Environmental Health Consultation Response

| Planning Ref | AL/143/24/RES |
| Site Description | Land At Woodgate Nurseries Lidsey Road Woodgate West Sussex |

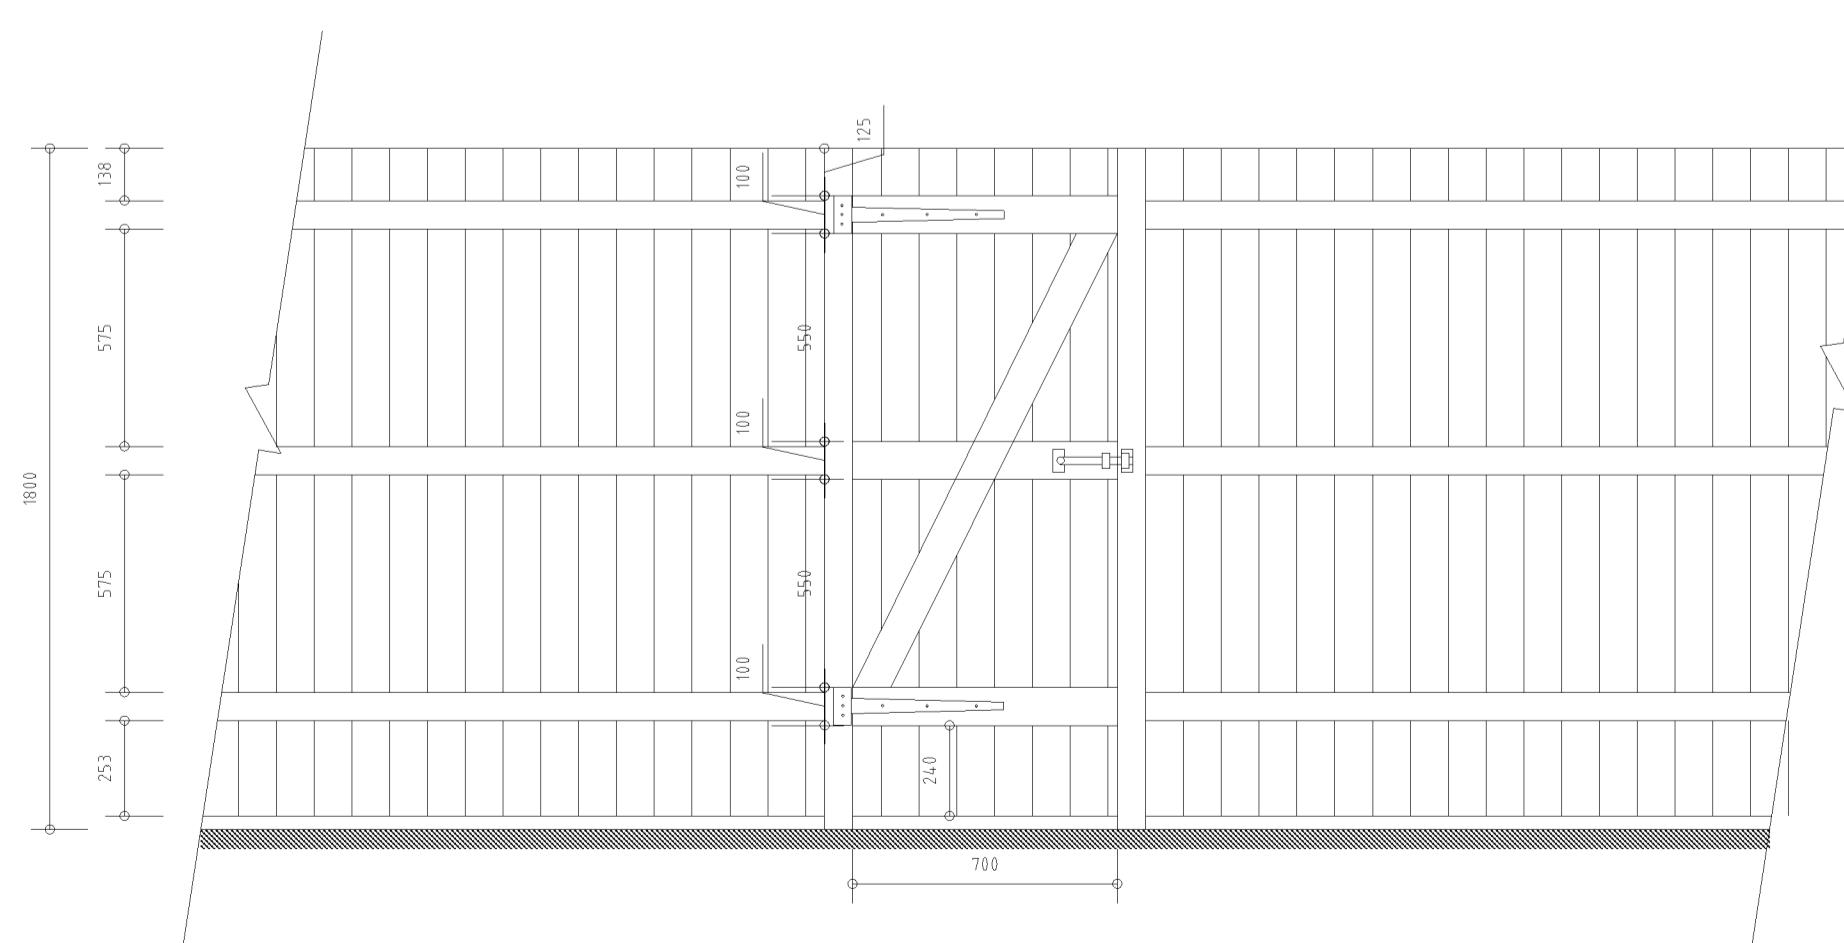
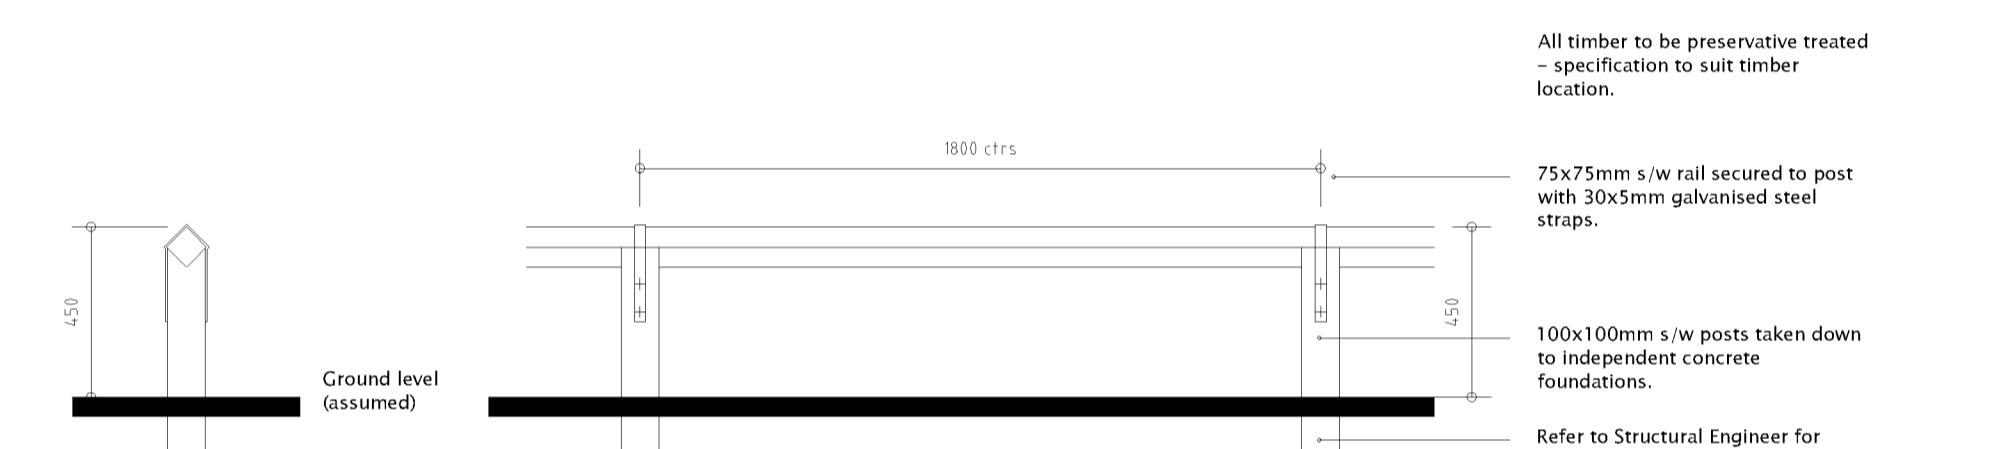
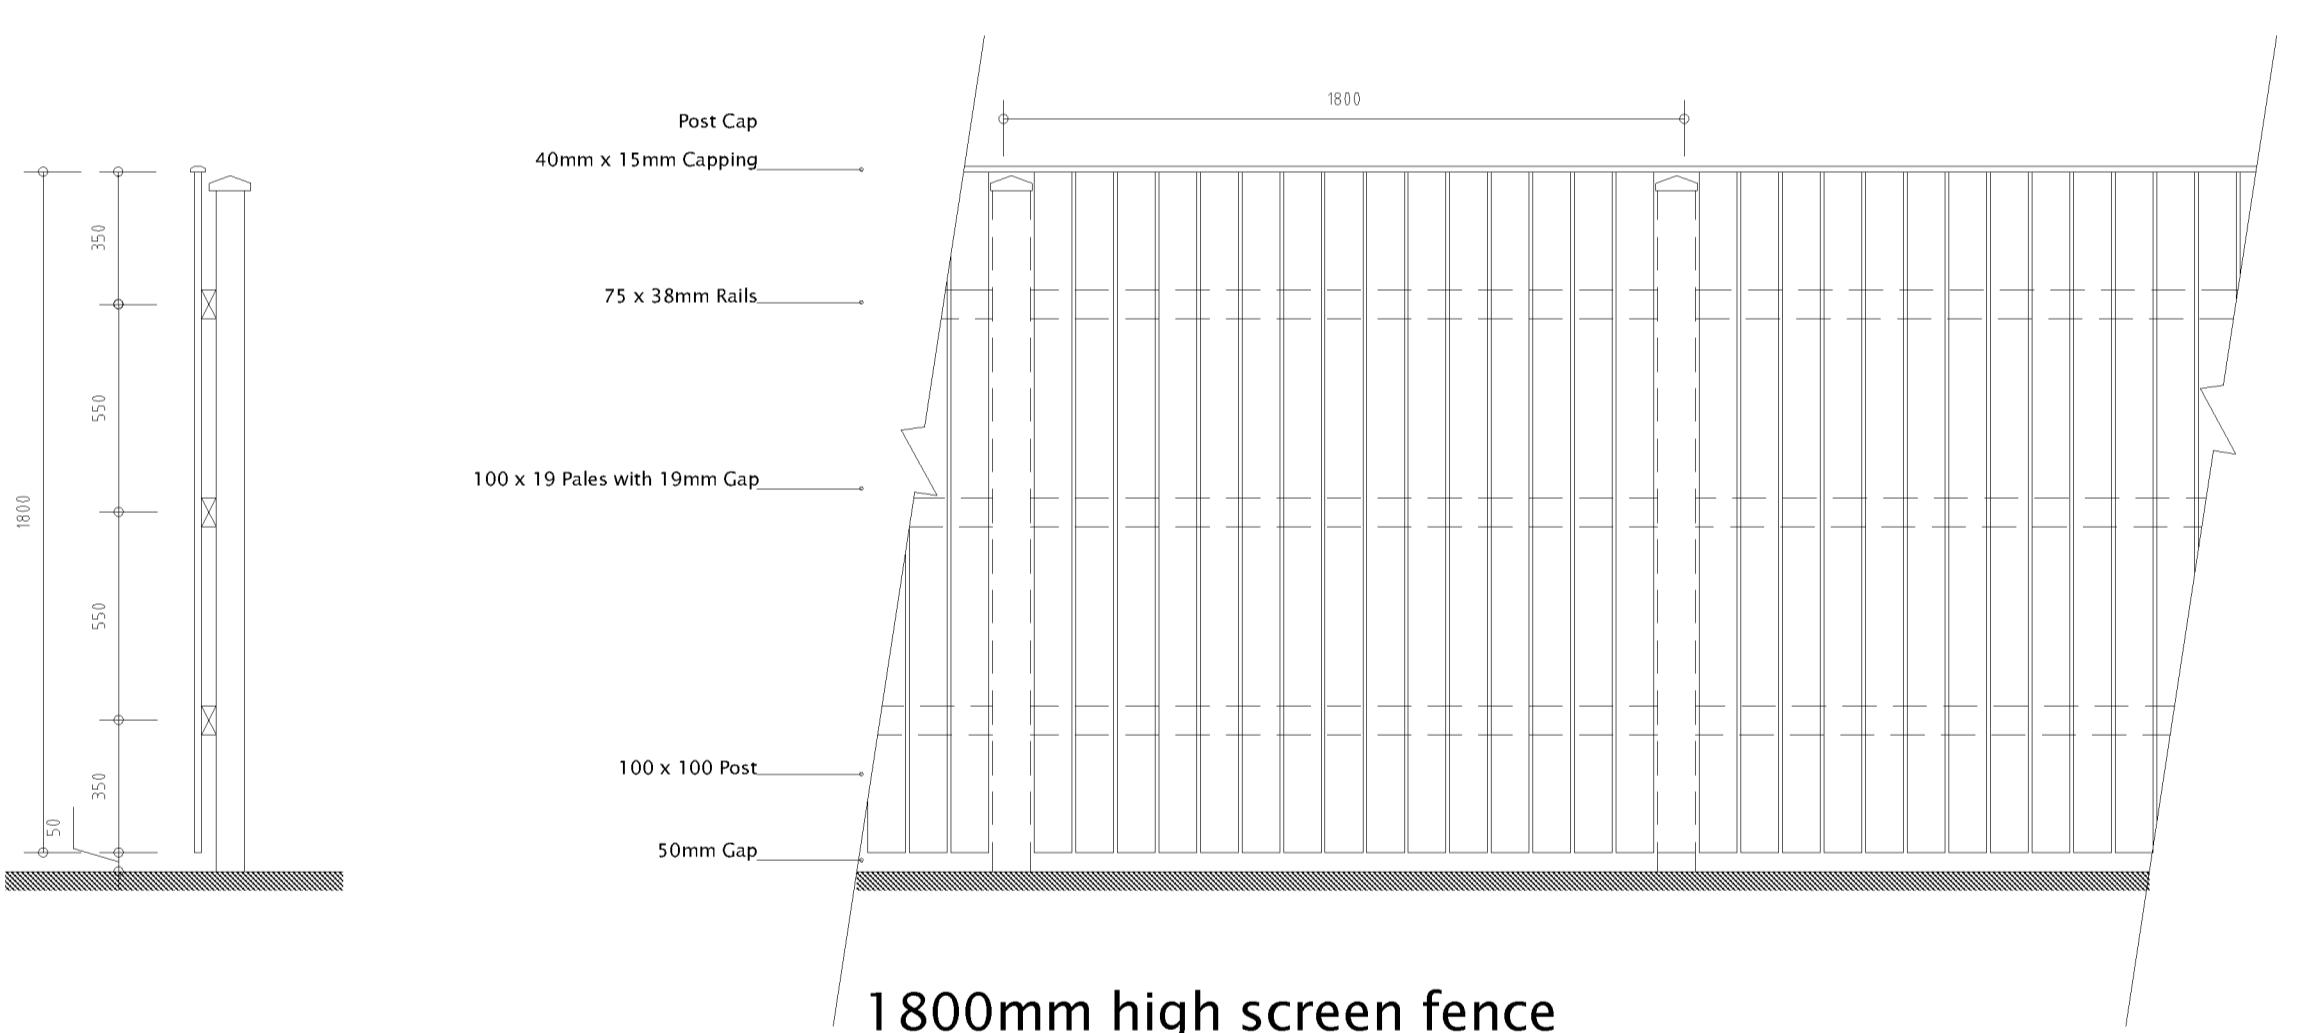
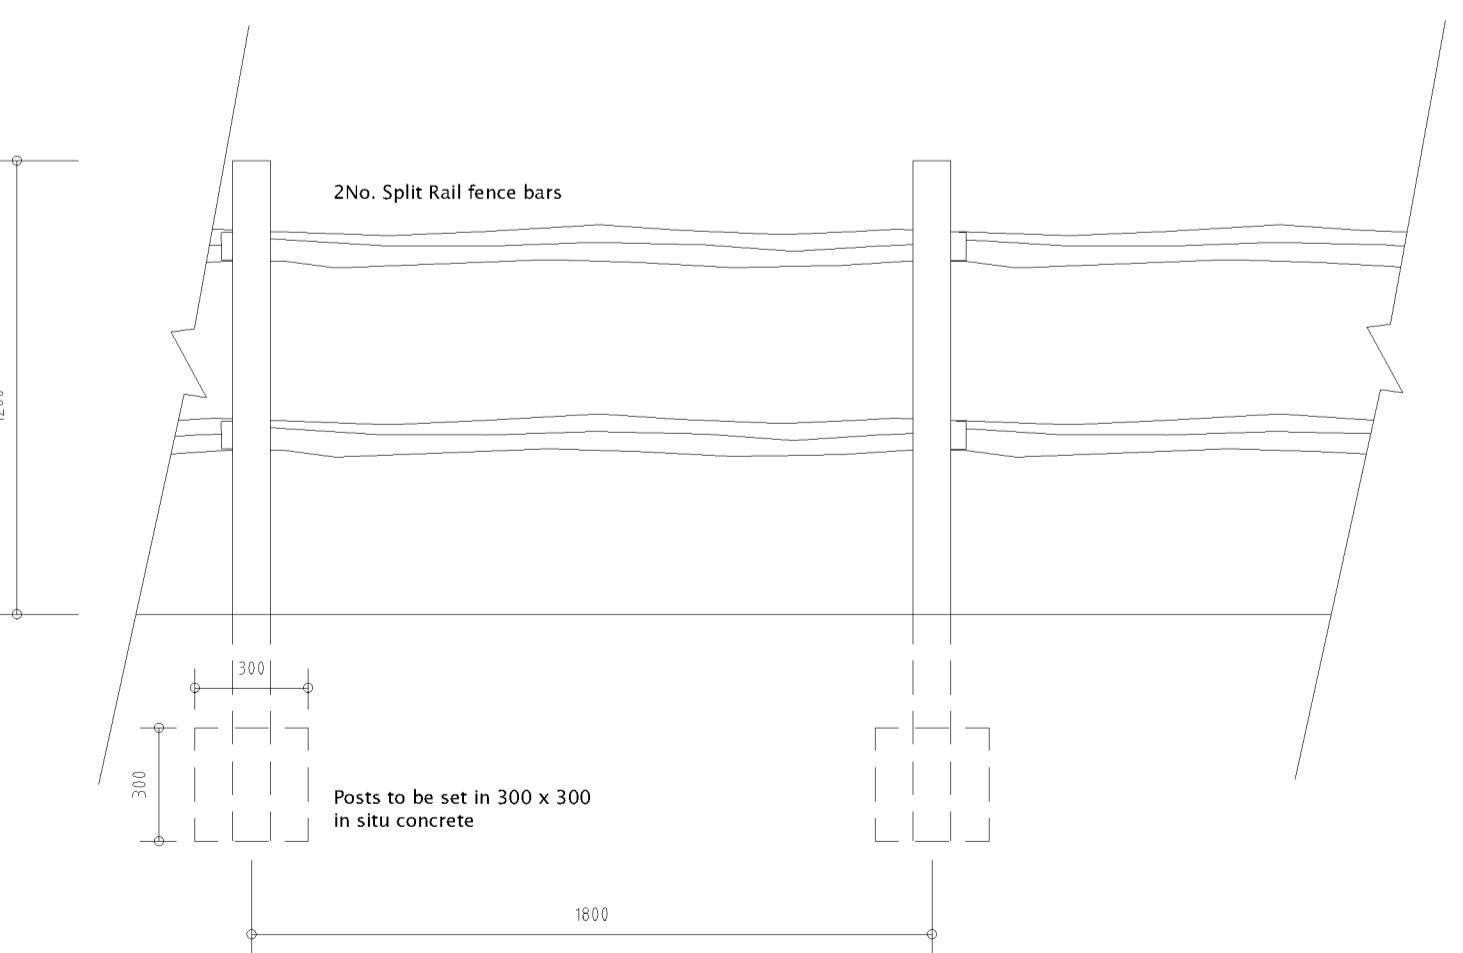
I have reviewed the submitted boundary treatment plans and am satisfied that it would comply with condition 7.
